**Subject:** RE: 20/500800/BOC - UPVC windows in Listed Building at 15a Gabriels Hill, Maidstone, Kent

A new planning application for Listed Building Consent will be required relating to 15a Gabriels Hill. To assist you, our Conservation Officer has provided the following information to enable your application to be approved without delay –

SECOND FLOOR
 15A GABRIELS HILL
 MADSTONE
 KENT ME15 6HR
 DRAWING NO
 WVE/2023/4
 SCALE 1:5

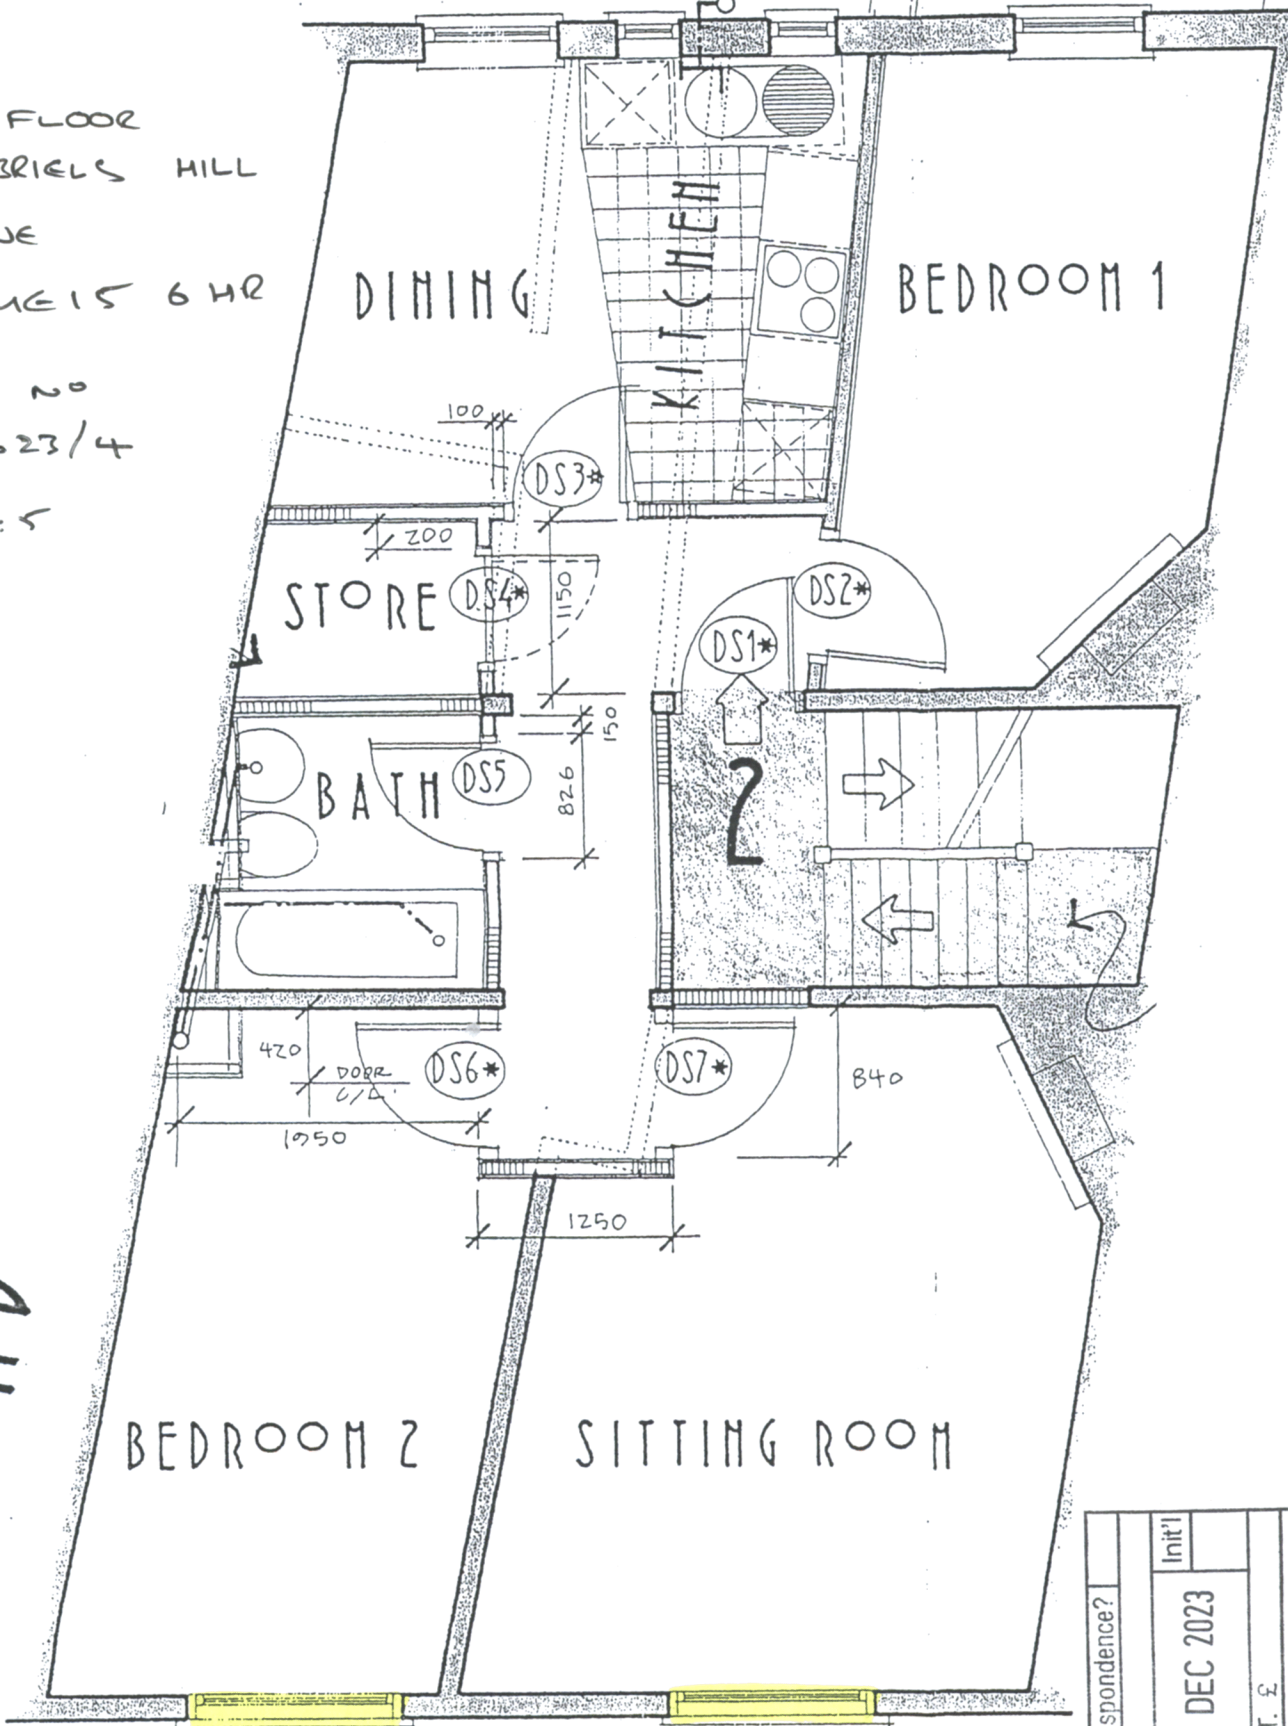
*The proposed windows should replicate the attached images which show 6 over 6 sash windows to the second floor and 8 over 8 sash windows to the first floor, which match those at No. 11 Gabriel’s Hill. The slender profile of the glazing bars and the sashes should match like for like.*

*For the proposed replacement of the illegally installed UPVc double glazed windows at 15A Gabriel’s Hill, we would accept an application for single-glazed, softwood sash windows with integrated glazing bars. I note that on the PDF submitted by the Agent for the proposed application, there is a drawing that includes slim-profile double glazing. We do not accept slim profile within listed building unless there is a clear heritage gain, ie, replacement of inappropriate 1980s storm windows with fanlights, to flush casement windows without fanlights.*

*As the windows are deemed to be C18 single-glazed, timber sash windows, with slender glazing bars, up-grading to slim-profile (or even standard) double glazing would not been considered acceptable. The slender sashes and glazing bars would not be able to support the increased thickness/weight to support slim-profile double glazing, and therefore they would need to be increased to take the extra depth/weight. This will alter the appearance of the windows and have a negative impact on the appearance of the property.*
